Application no: 22/03693/DISC

Location: Land Adj To Promised Land Farm, Wendlebury Road, Chesterton

Lead Local Flood Authority

Objection

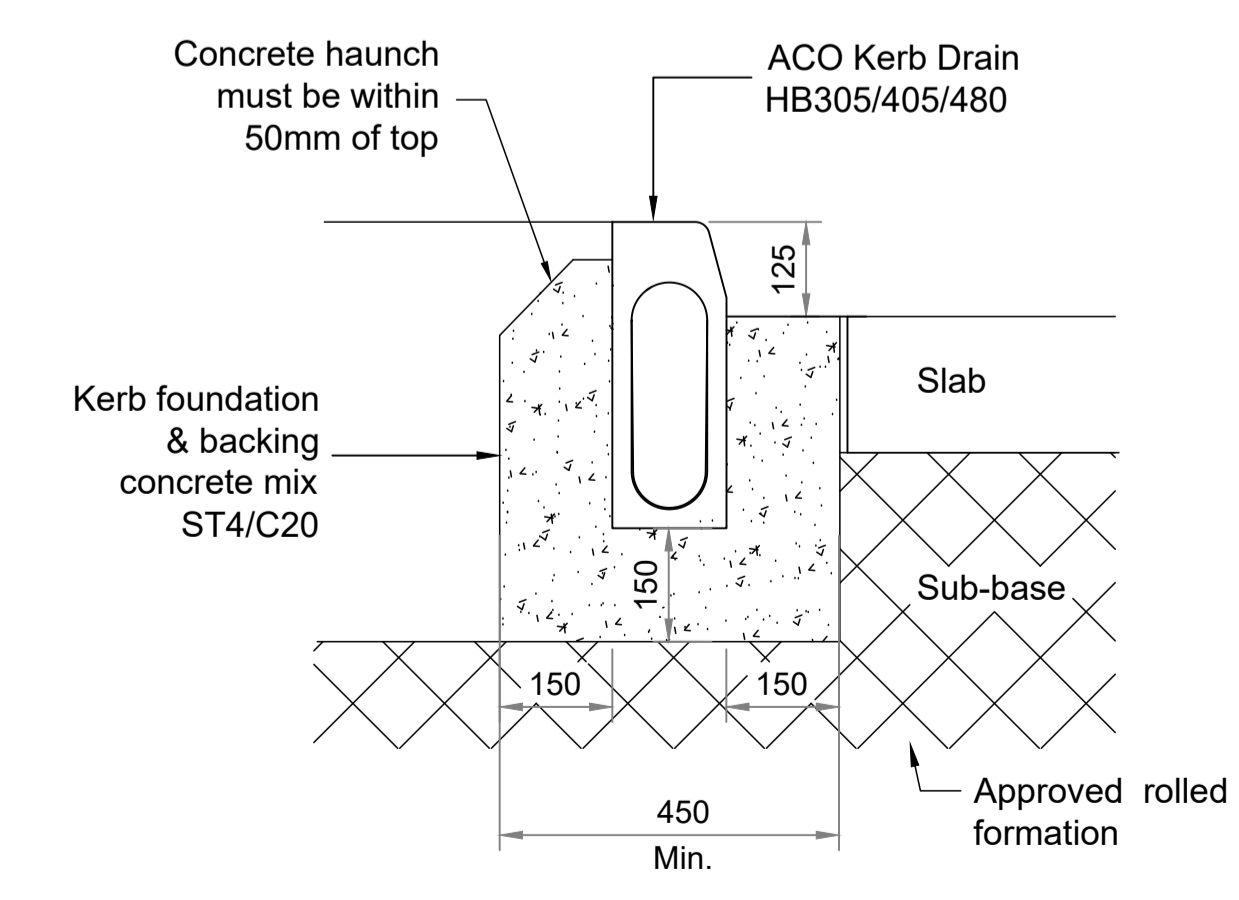
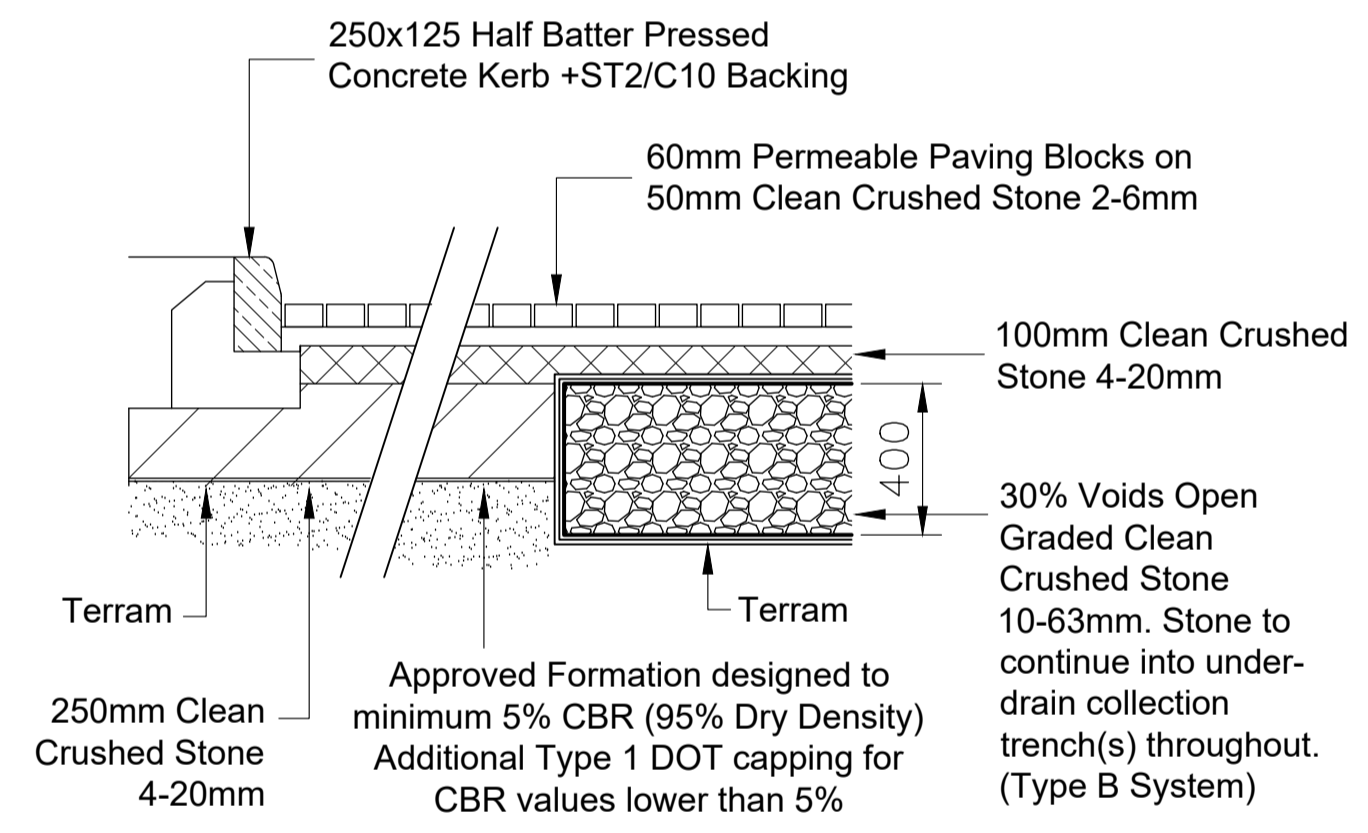
- Provide pipe numbering on the drainage plan which should read in line with the calculations produced.
- Provide SuDS construction details drawings.
- Provide consent to discharge to the existing watercourse. Confirm the capacity of the ditch to take the proposed loads without posing flood risk to the neighbouring sites.
